## RE: Walker-Wilson Short Plat (SP-07-150)

The Kittitas County Community Development Services Department has determined that the Walker-Wilson Short Plat (SP-07-150) is a complete application and hereby grants **conditional preliminary approval** subject to the following conditions:

TO: Trudie Pettit, Community Development Services  
FROM: Christina Wollman, Planner II *cw*  
DATE: July 30, 2008  
SUBJECT: Walker-Wilson Short Plat SP-07-150

WALKER SHORT PLAT
 PART OF SECTION 32, T. 18 N., R. 19 E., W.M.
 KITTITAS COUNTY, WASHINGTON

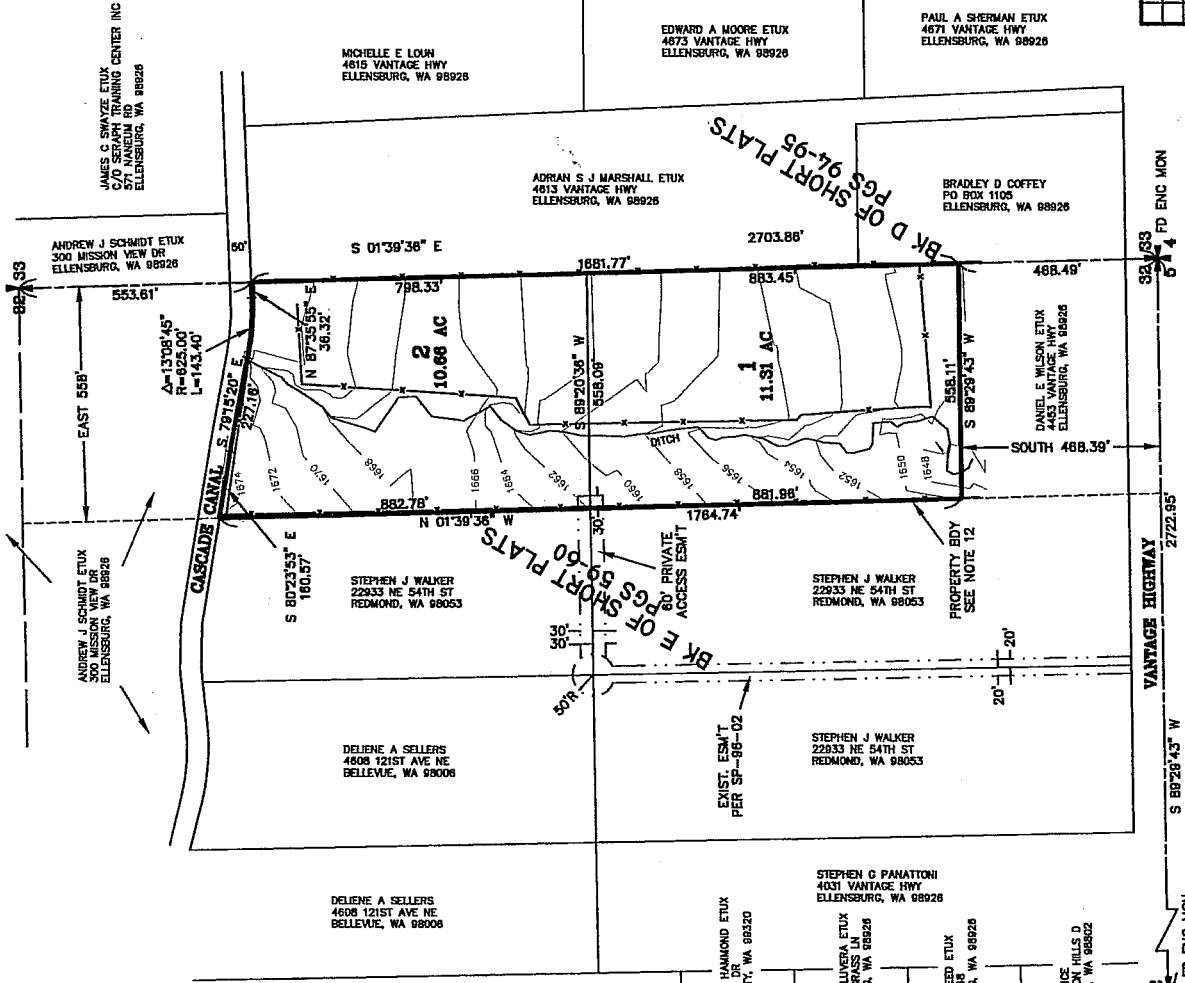
1. Both sheets of the final mylars shall reflect short plat name Walker-Wilson and short plat number SP-07-150 and an accurate legal description shall be shown on the face of the final plat.

10. Private Road Improvements: Access from Vantage Highway to the cul-de-sac shall be constructed to meet or exceed the requirements of a Low-Density Private Road. See Kittitas County Road Standards, 9/6/05 edition.

- a. Access easements shall be a minimum of 60' wide. The roadway shall have a minimum width of 20', with 1' shoulders, for a total width of 22'.
  - b. Minimum centerline radius will be 60'.

11. Cul-de-Sac: A cul-de-sac turn-around having an outside right-of-way easement diameter of at least 110 feet shall be constructed at the closed end of all dead-end roads serving 3 or more lots. The driving surface shall be at least 96 feet in diameter. Cul-de-sacs must also conform to the requirements specified by the 2006 International Fire Code. Contact the Fire Marshal regarding any additional cul-de-sac requirements.

12. Lot 1 and 2 Access: From the cul-de-sac to the entrance to Lots 1 and 2, the access shall be constructed as a joint-use driveway.

- a. Access easements shall be a minimum of 20' wide. The roadway width shall have a minimum width of 12'.
  - b. The surface requirement is for a minimum gravel surface depth of 6".
